**Cedar Lodge, North Side, Steeple Aston, OX25
4SE**

23/02834/LB

Proposal: Repairs, refurbishment and alterations to existing stone/brick outbuildings to provide pool plant room and changing facilities

TITLE
 JOINERY - PROPOSED TIMBER
 STAIRCASE TO EXSTG. LIVING AREA

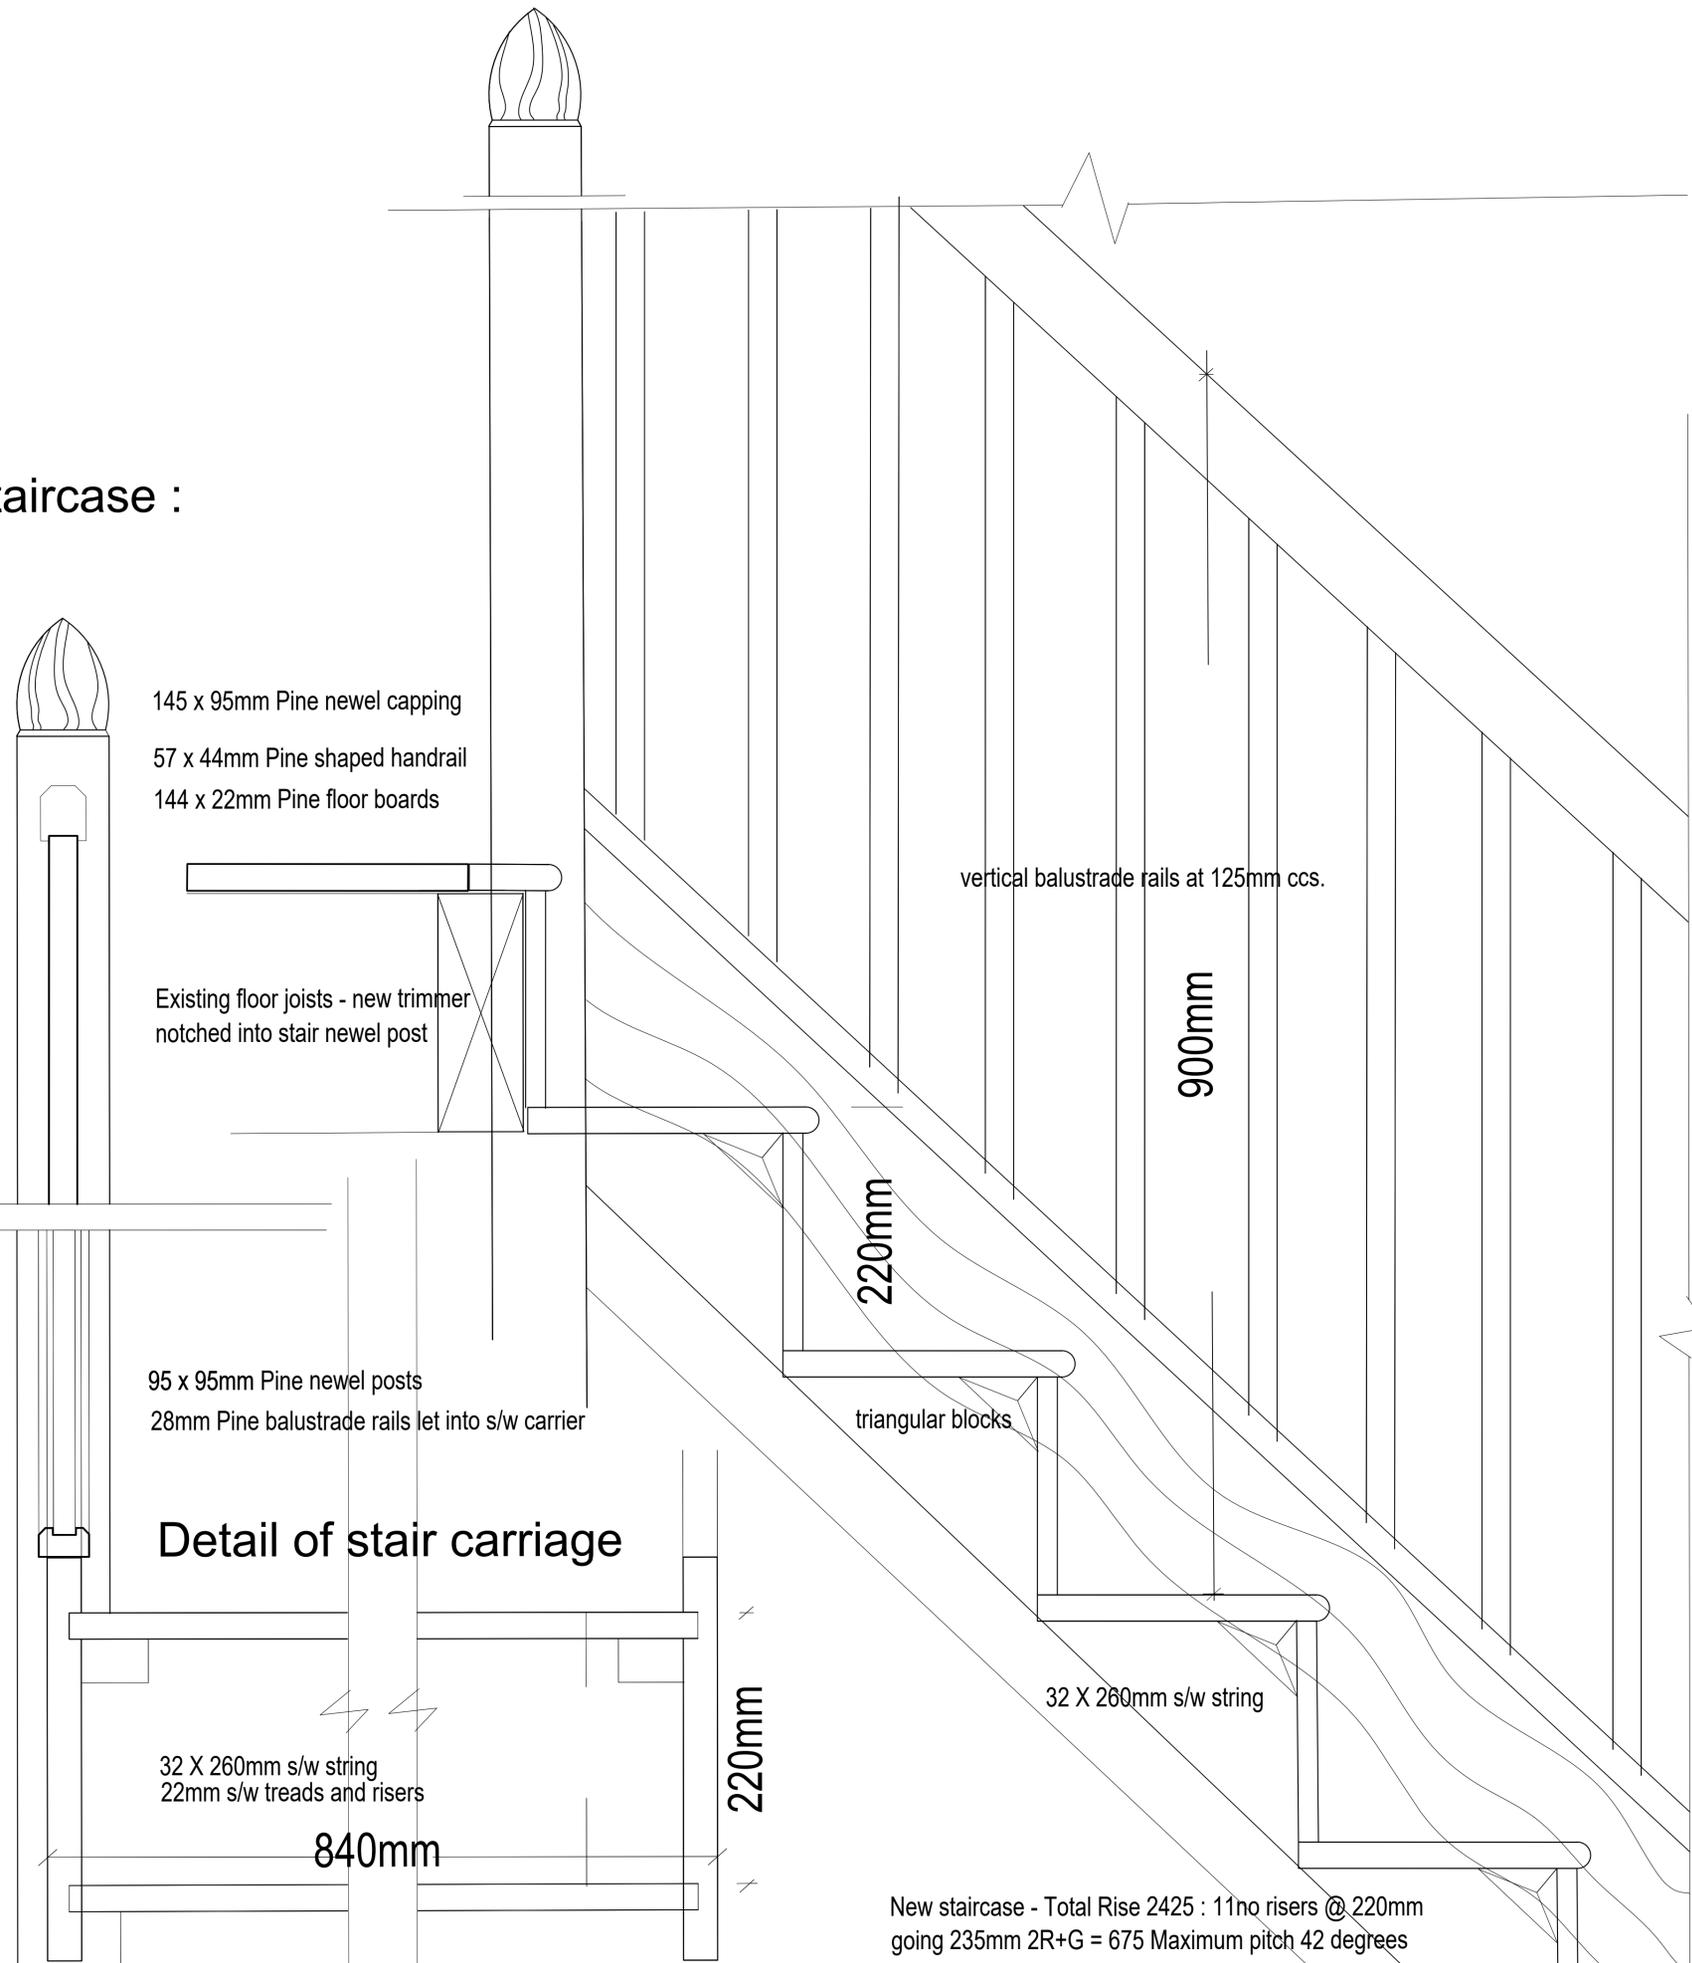
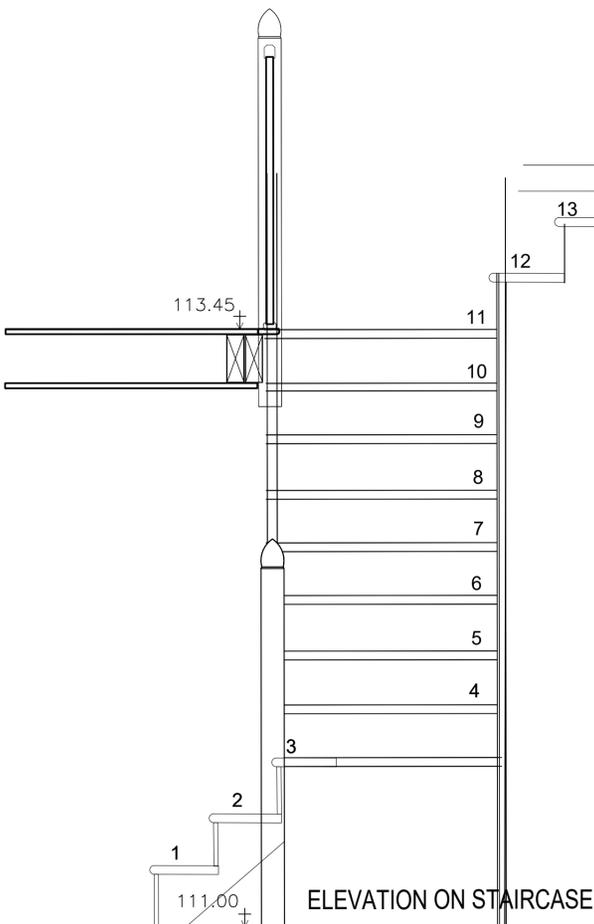
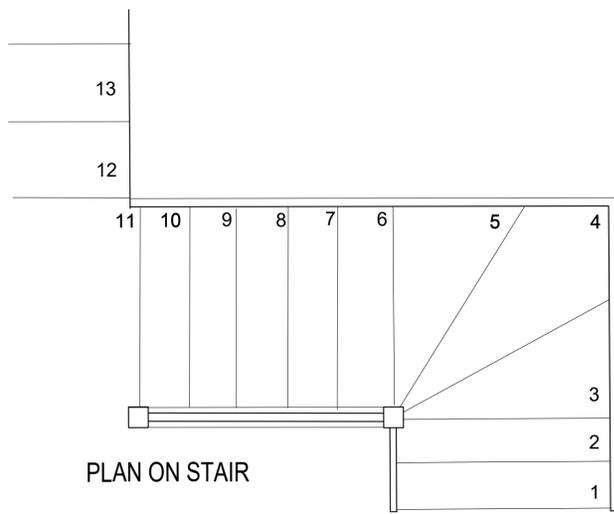
- No objections are raised to the loss of existing staircase which is not of any architectural or historic significance.

JOB	CEDAR LODGE NORTH SIDE STEEPLE ASTON OX25 4SE	
CLIENT	ALEX & FRANCIS PASTEUR	
TITLE	PROPOSED ALTERATIONS TO OUTBUILDINGS-POOL & PLANT	
SCALE	DATE	DRWG. REF.
1:50	JULY 2023	668.04

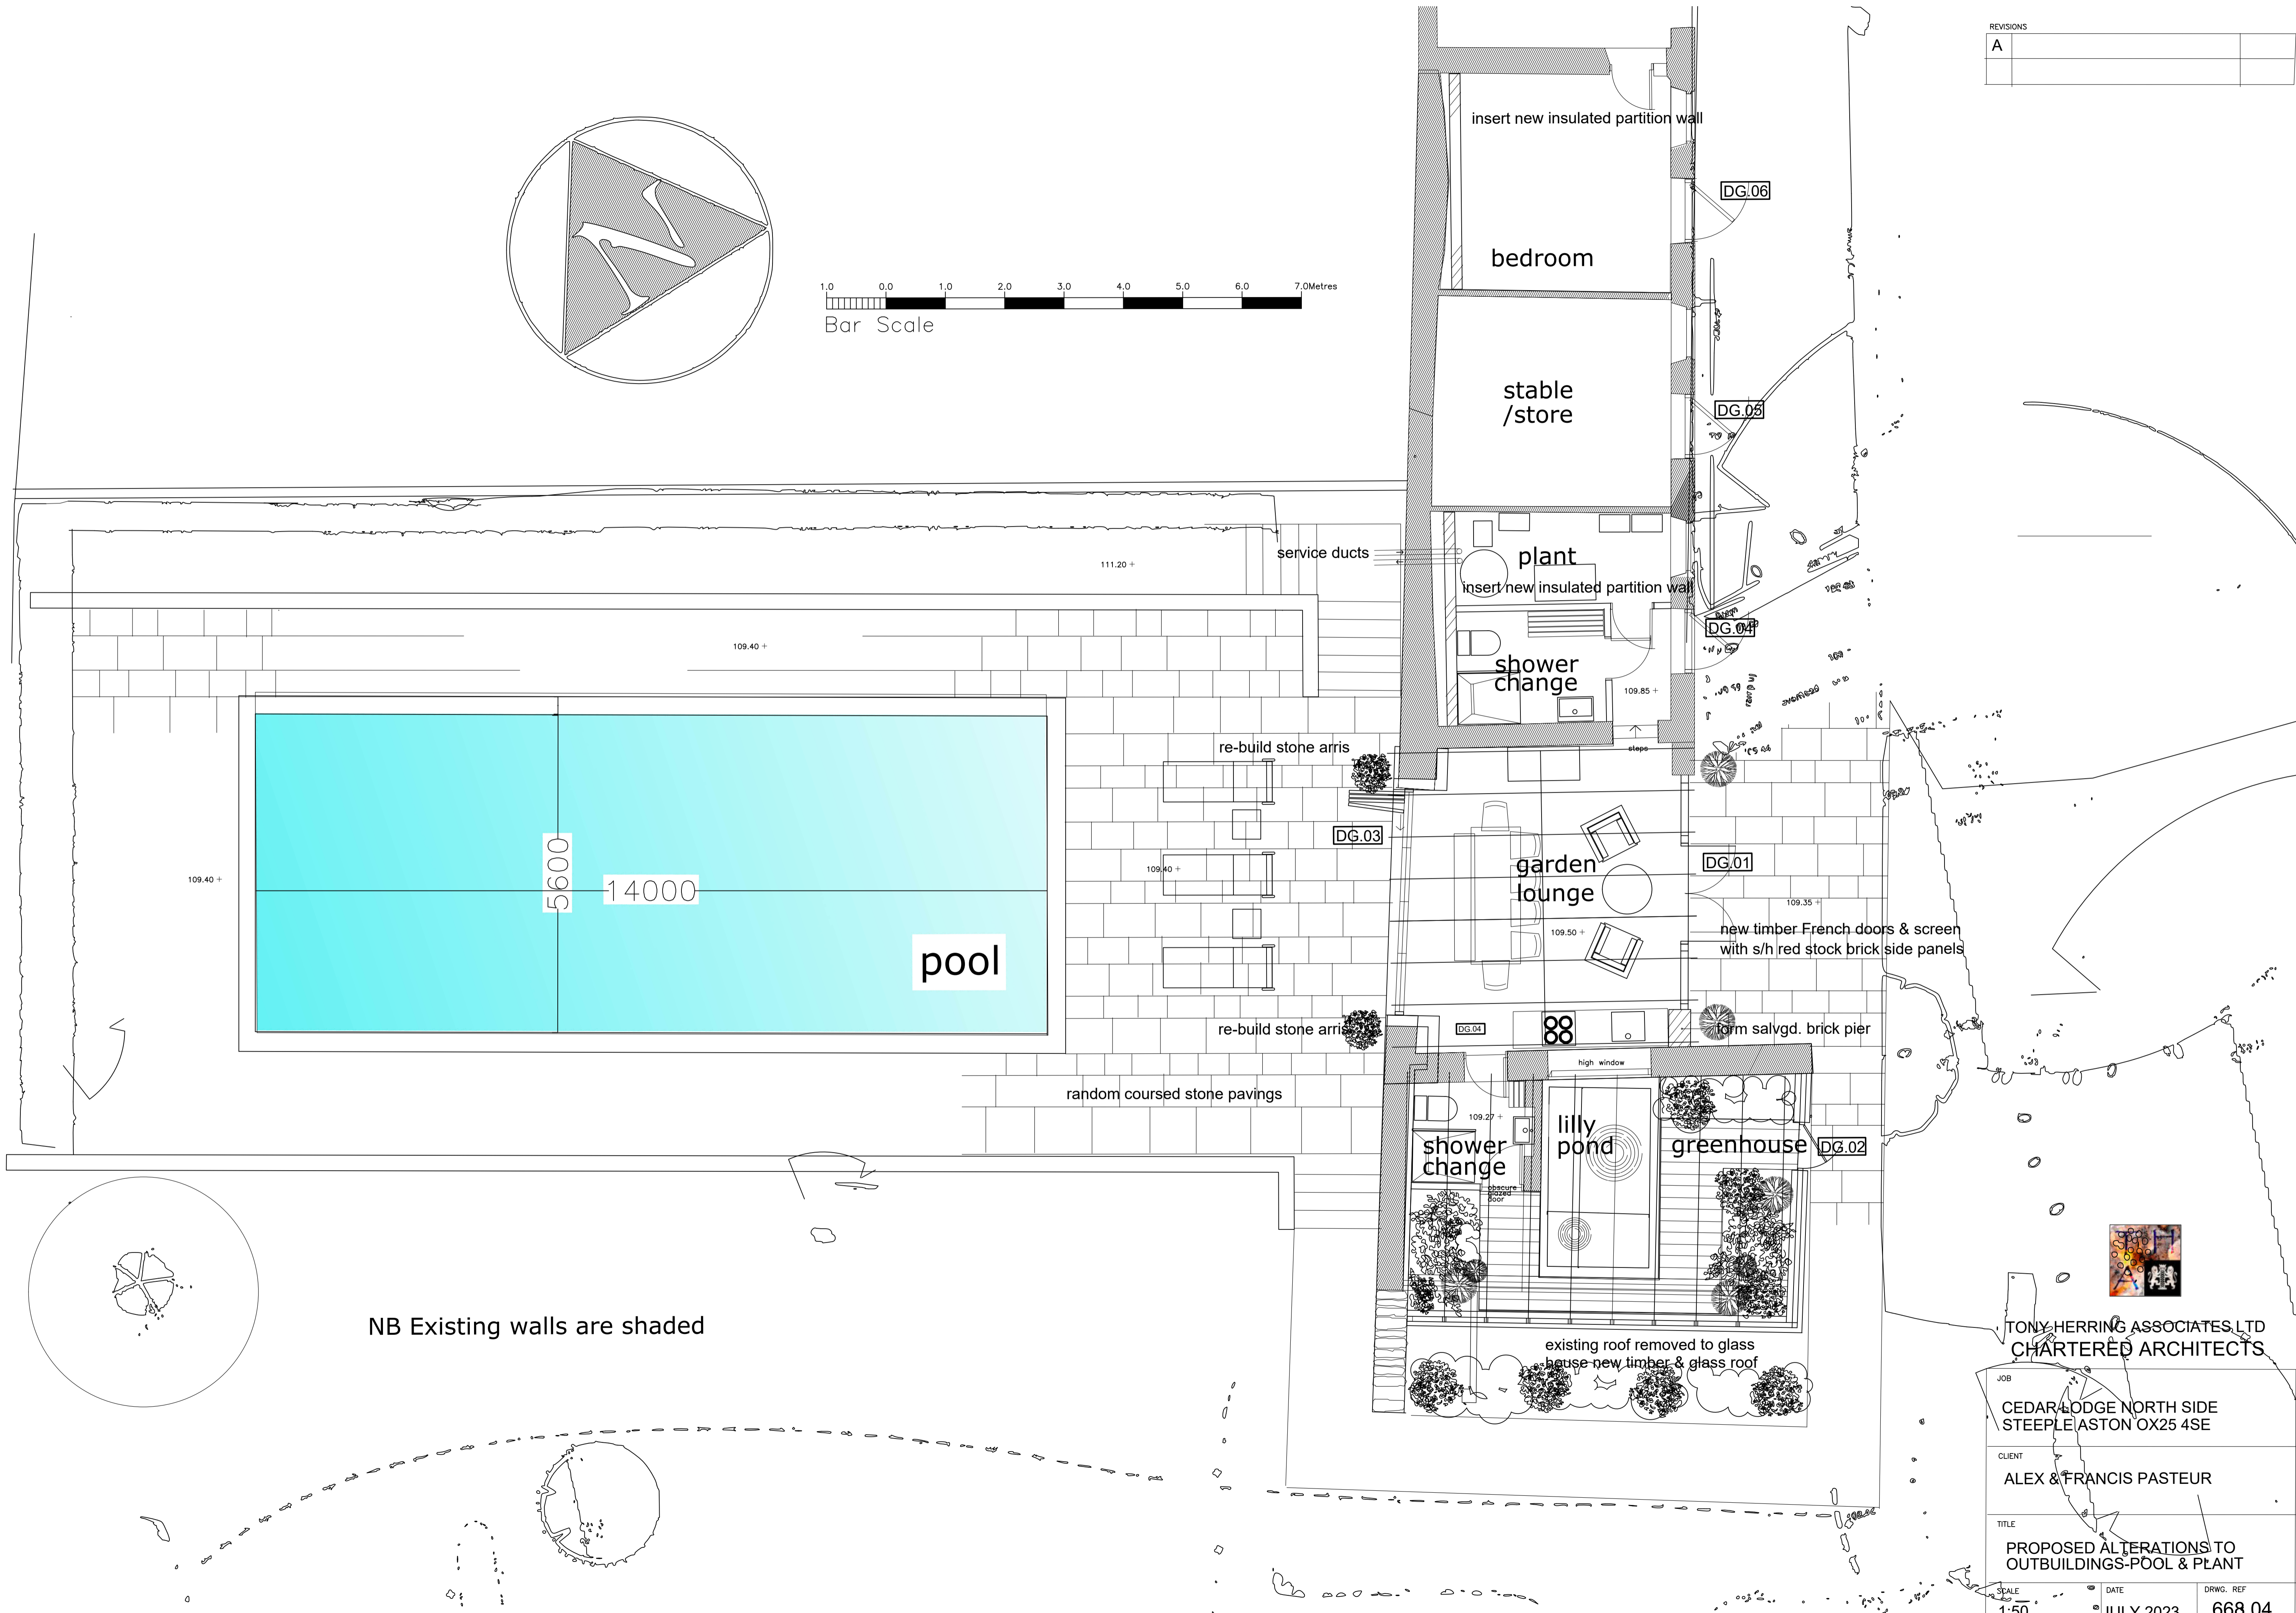
- No objections are raised to the proposals to dismantle and remove the post 1974 workshop.
- No objections are raised to the proposed replacement structure, subject to the submission of further details including detail drawings and sections at a scale of 1:20 (or larger) with 1:5 sections (or larger), of proposed roof, eaves/ verge, rainwater goods, doors and windows. In addition, a sample panel of proposed brickwork (showing brick type, brick bond and mortar specification) should be agreed in writing by the LPA prior to the relevant phase of works. Any proposed windows and doors must be slimline with minimal section sizes.

- No objections are raised to the proposed roof works. However, the submission of a slate sample (slate required to make up any shortfall) will be required with supporting technical specifications.
- Further details are required of the proposed new opening and steps to plant room.

- We welcome proposals to restore the green house and former plunge pool. Samples are required of the proposed brick type intended to make up the shortfall for the brick plinth. The bond, pointing profile and mortar must be to match existing and a brick sample panel must be agreed in writing by the LPA prior to the relevant phase of works.

7. Prior to the creation of the new opening between the shower/plant room and the garden lounge hereby approved, full details of the proposed opening and steps between the shower/plant room and the garden lounge hereby approved, at a scale of 1:20 including a cross section, cill, lintel and recess detail and colour/finish, shall be submitted to and approved in writing by the Local Planning Authority. The doors and windows and steps shall not be installed other than in strict accordance with the approved details.

9. Prior to the construction of the glazed link full details and sections at a scale of 1:20 with 1:5 sections of the proposed roof, eaves and verges shall be submitted to and approved in writing by the Local Planning Authority. The development shall not be carried out other than in accordance with the approved details.
